RE: Harnett County Land Use Application HTE #06-5-13836

Based on the criteria set out in Title 15A, Subchapter 18A, of the North Carolina Administrative Code, Rules .1950, the evaluation indicated that the site is **UNSUITABLE** for the addition requested. Therefore, your request for an existing tank is **DENIED**. The site is denied based on the following:

SITE PLAN APPROVAL

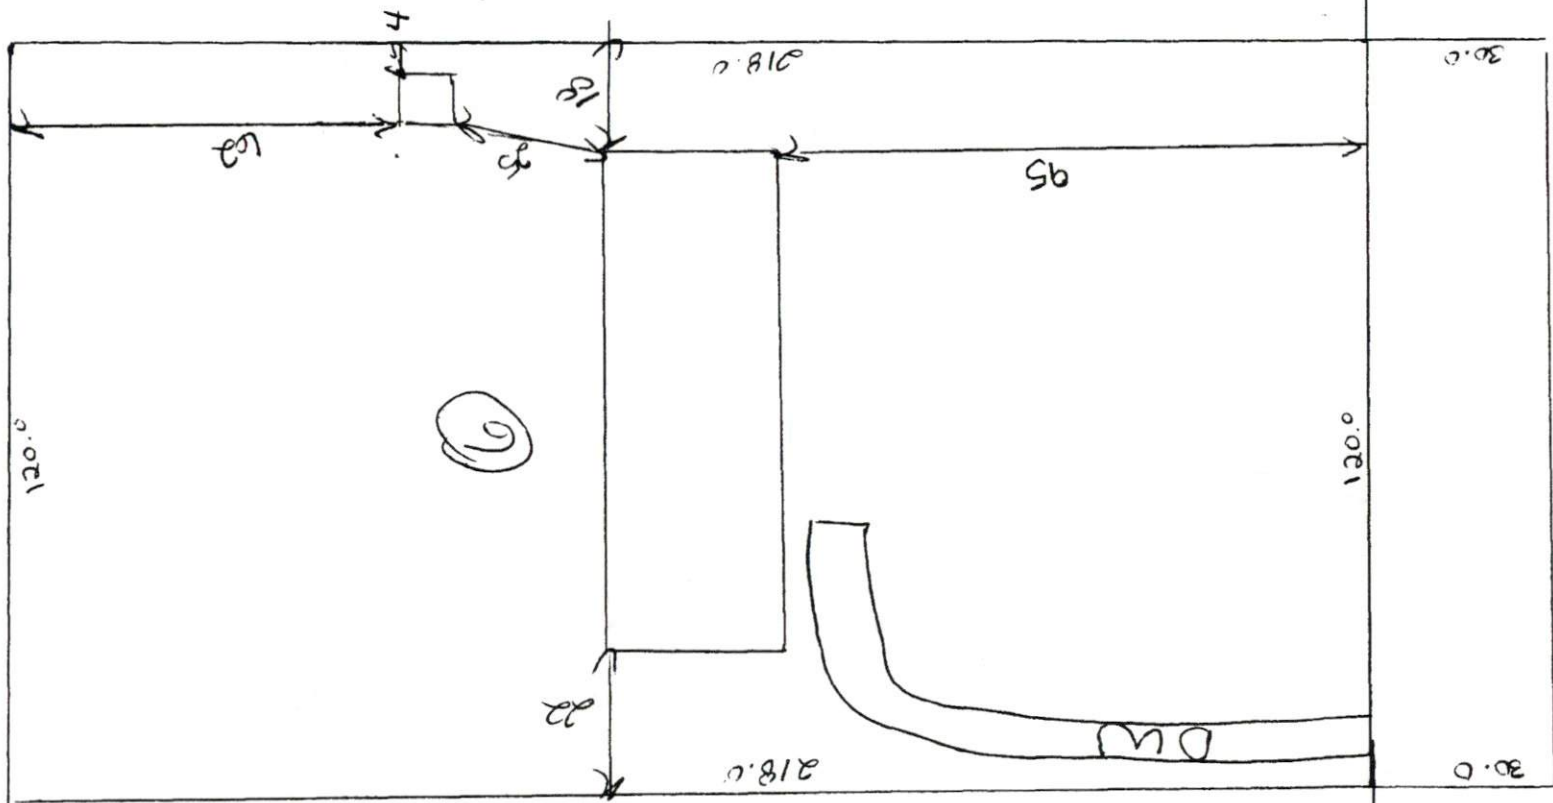
- 15A NCAC 18A.1950 a(16) Any swimming pool must be 15' from any part of septic system.
- 15A NCAC 18.1945 (b) Each lot shall have original septic system plus repair area.
- 15A NCAC 18A.1950 (10) – Any building to be 5' from drain line.

You are requesting a 4 bedroom mobile home, but the original permit is for a 3 bedroom. You can either replace home with a 3 bedroom home or apply for a soil evaluation for a 4 bedroom home at Central Permitting, and we can see if the 4th bedroom can be added by adding more drain line.
